PLANNING AMENDMENT

PLOT 5, OFF ROMAN RD, MOUTON CHAPEL.

Description: Erection of house and garage
(Plot 5)

Amendment: Sun lounge, conversion of garage to study and repositioning
of rear first floor window (Dwg. No. DGM-MC.2/3D & 5B)

DETERMINED
PLAN

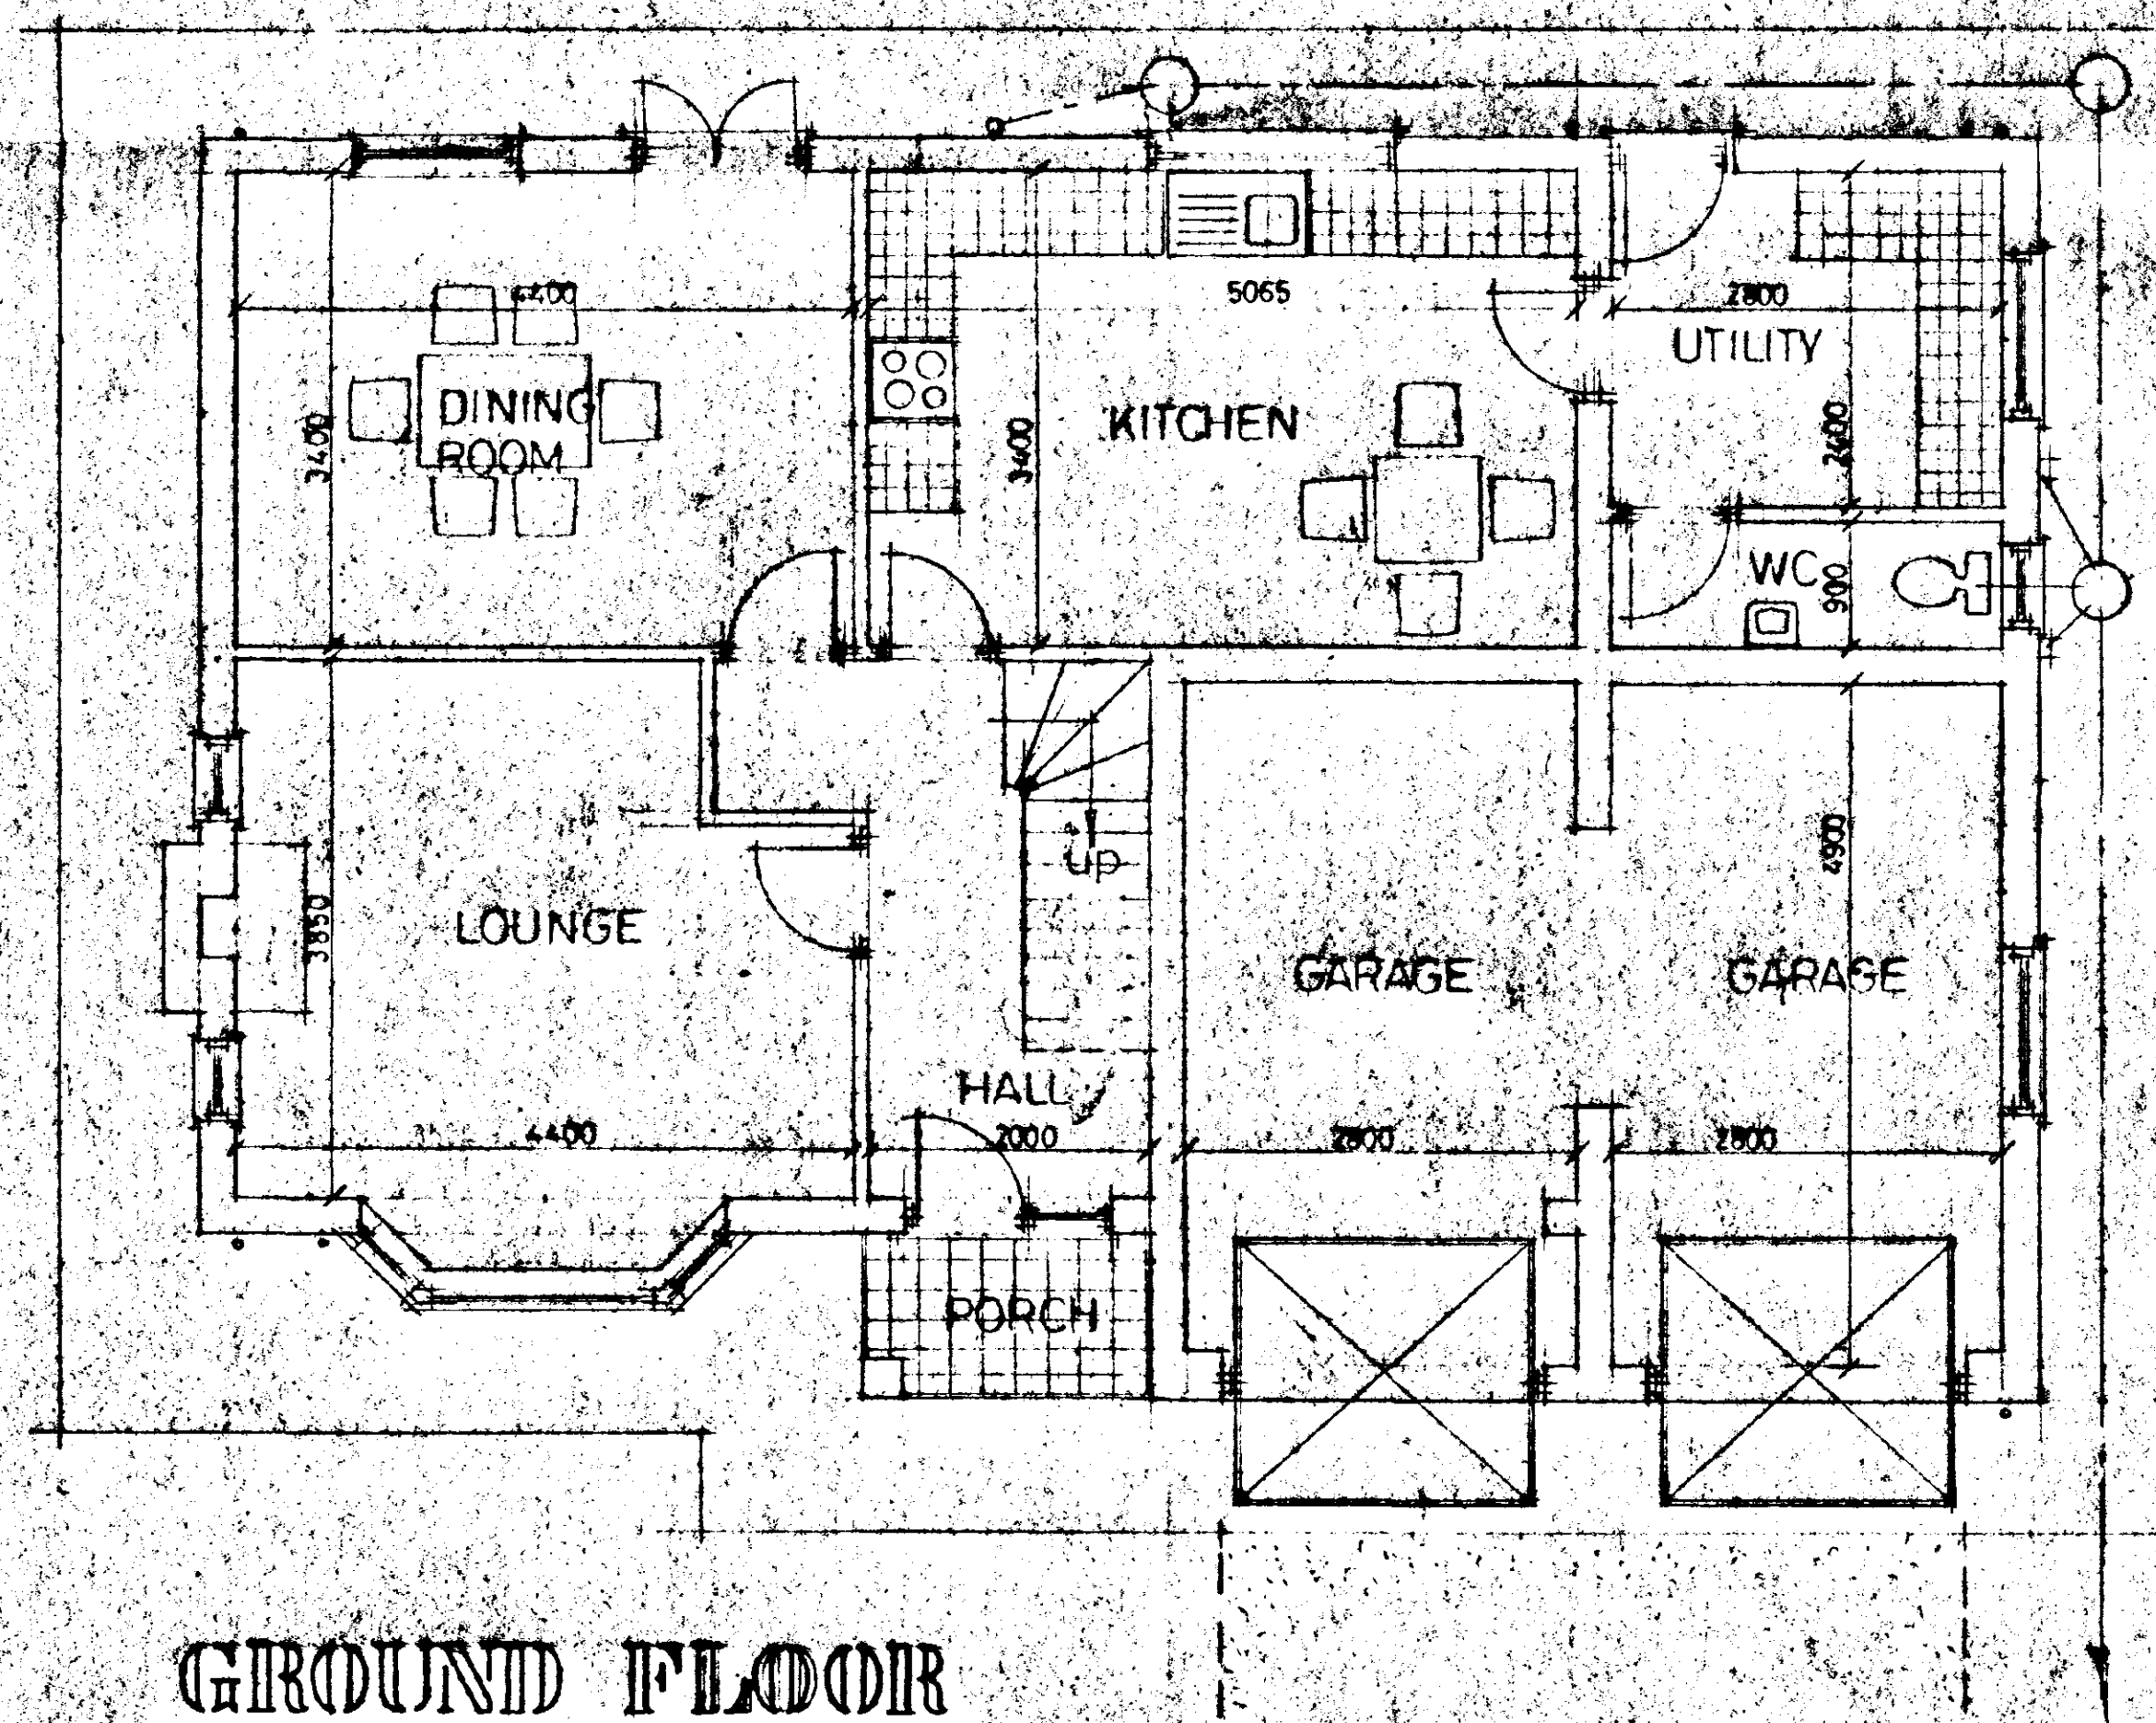
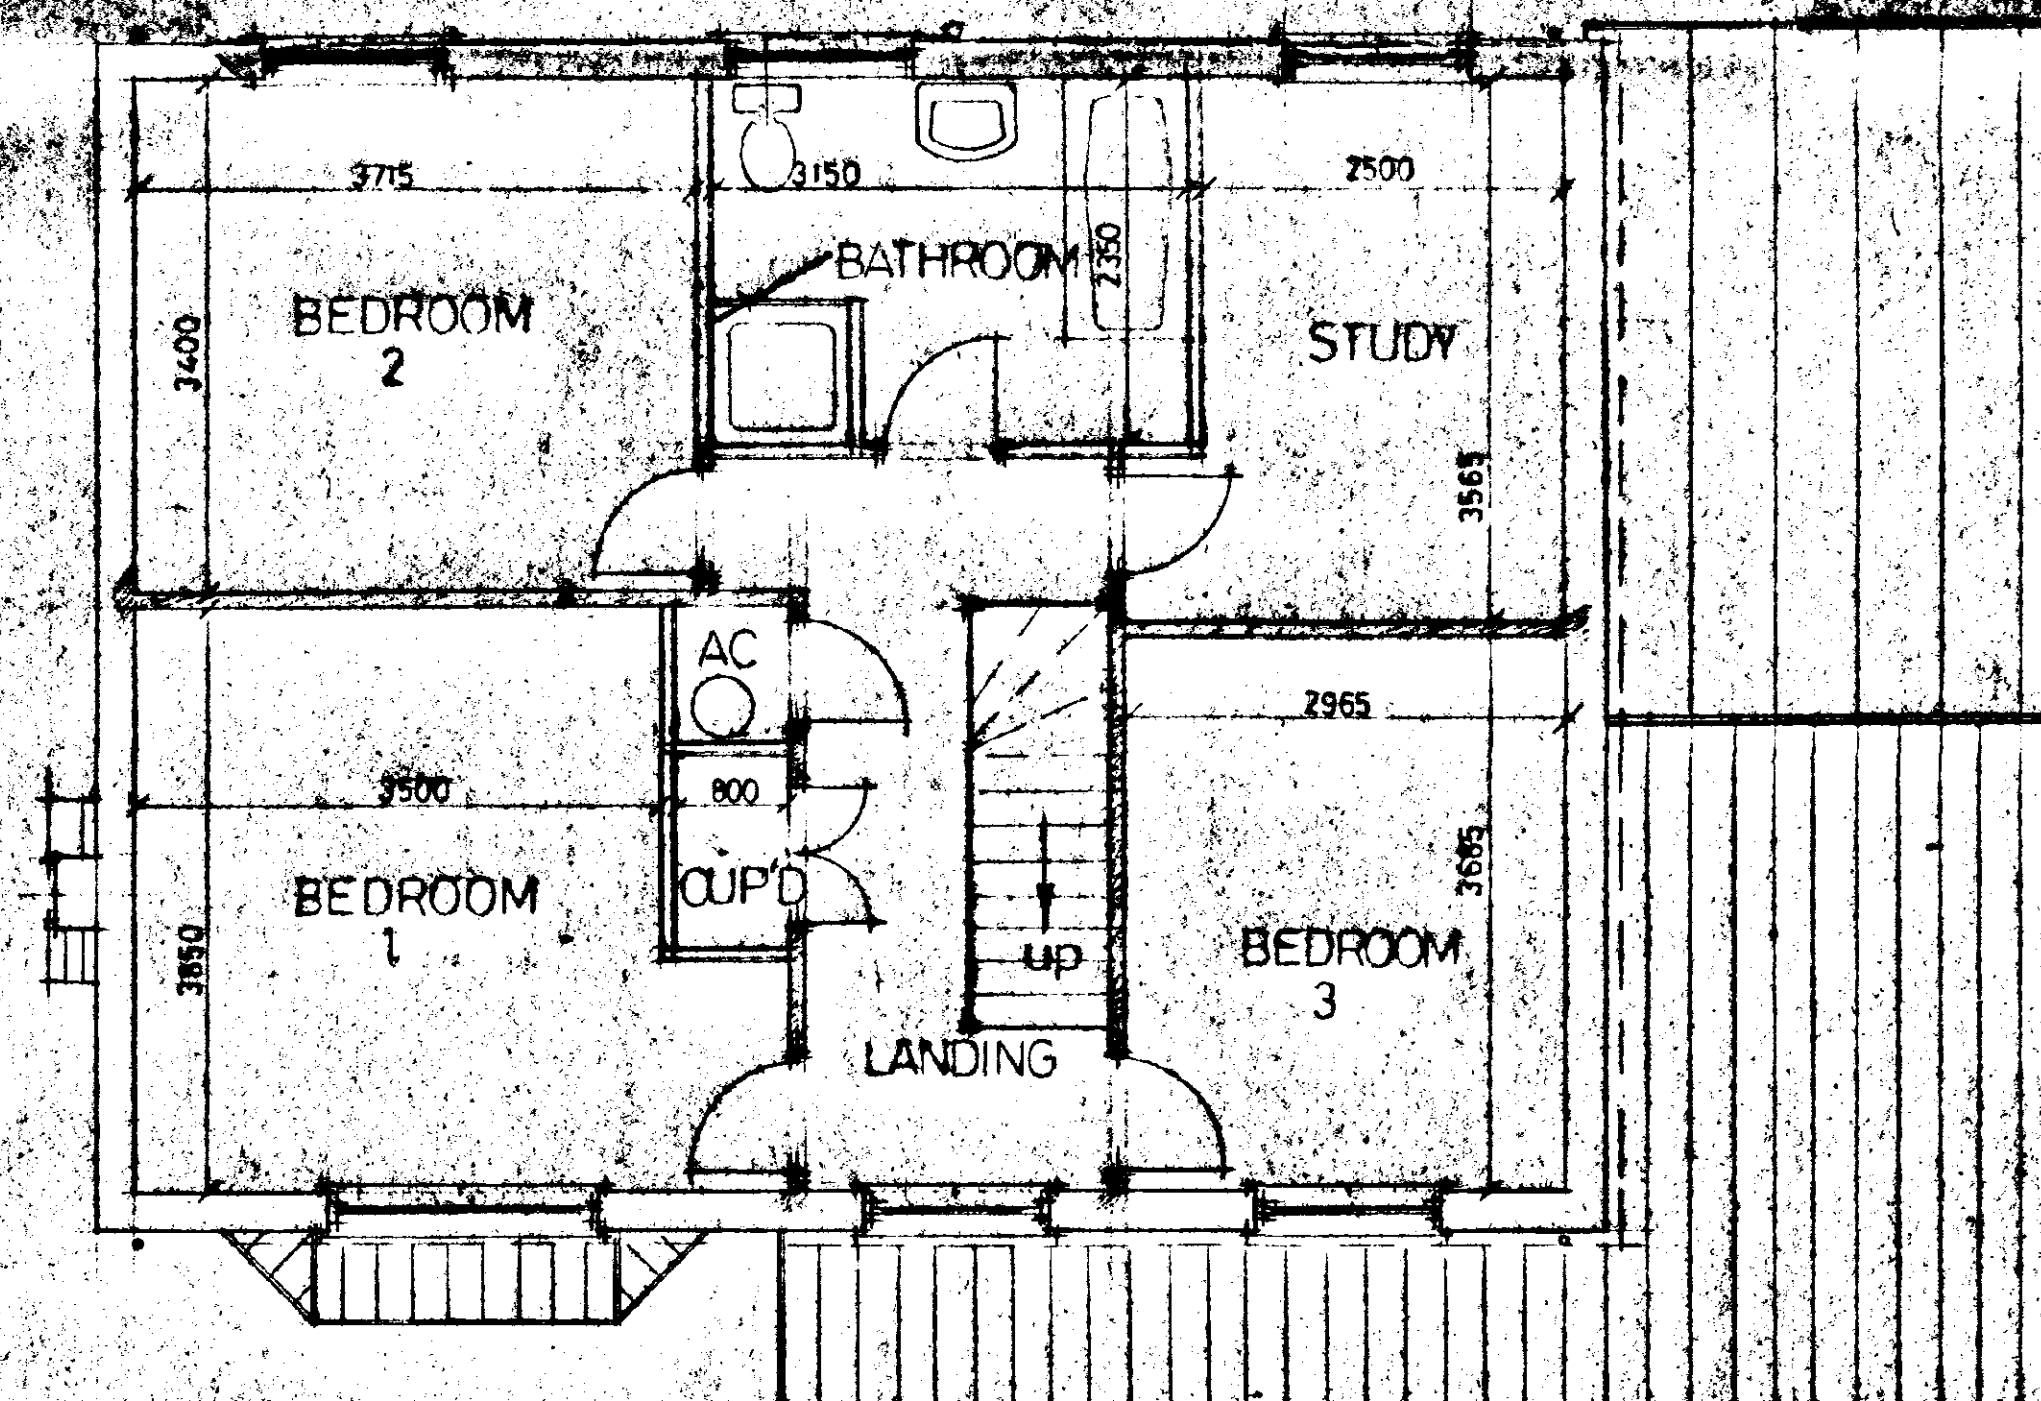
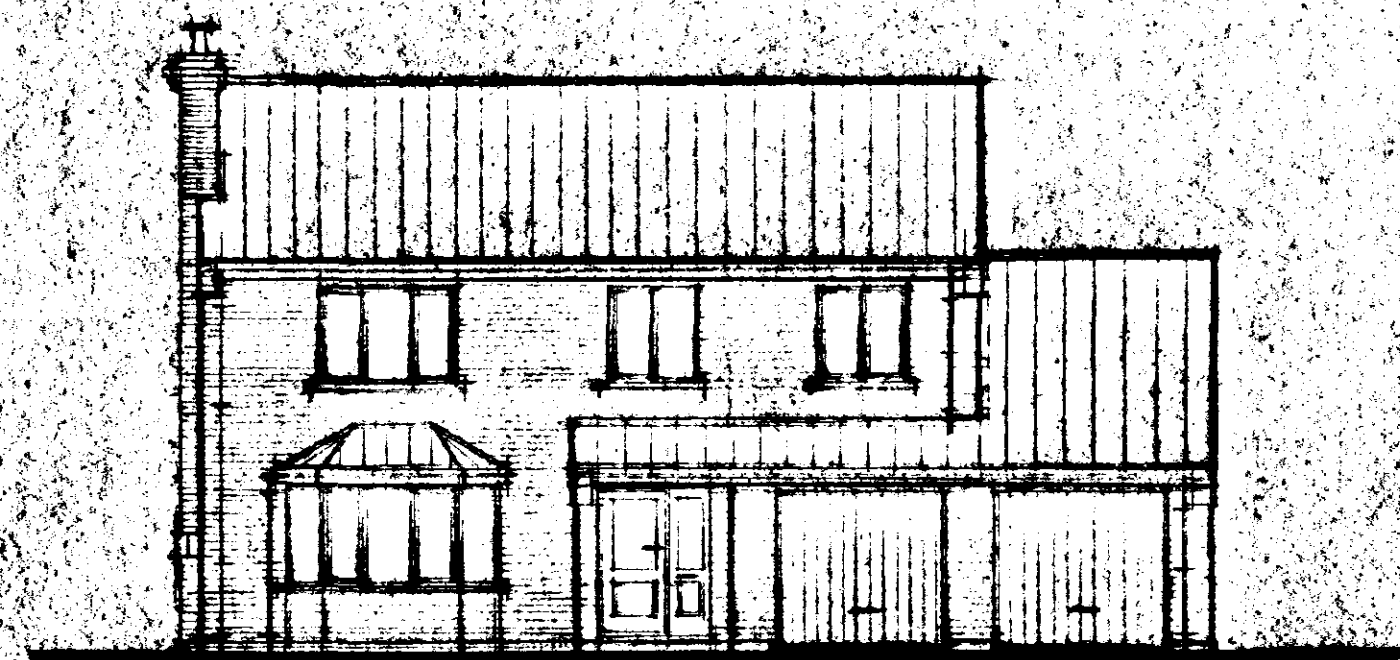
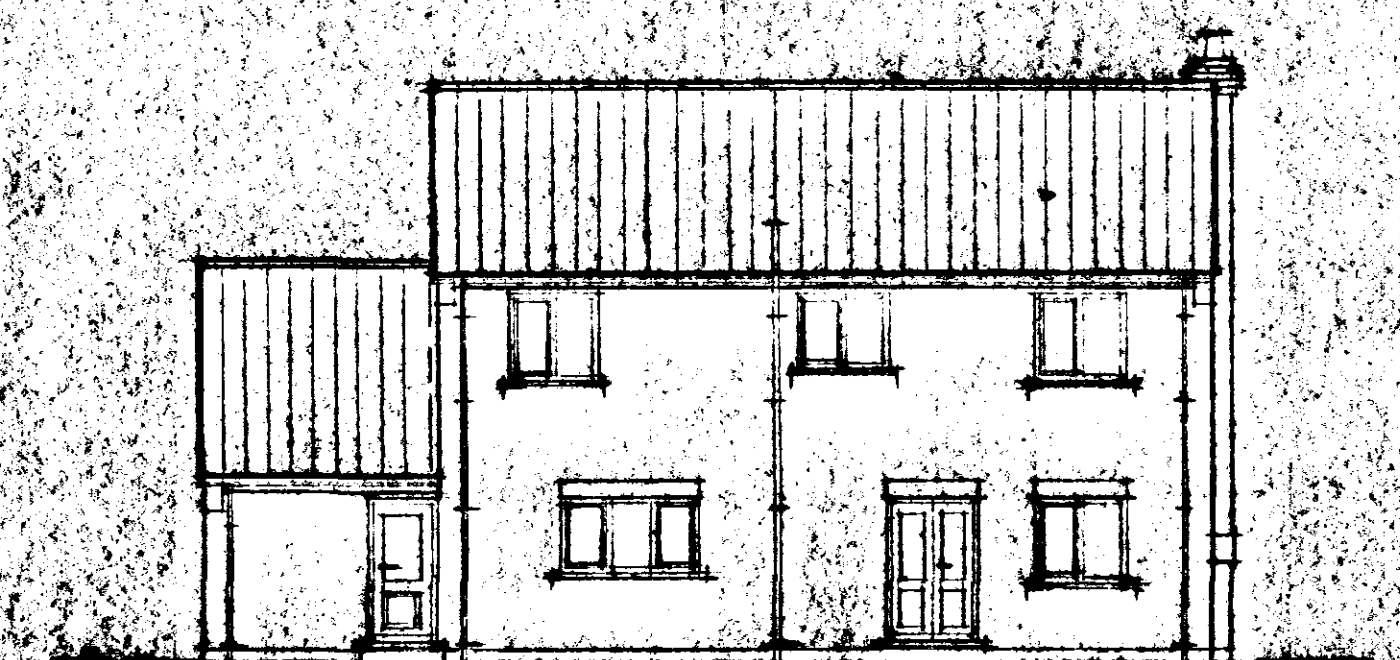
SUN-LOUNGE & GARAGE TO STUDY
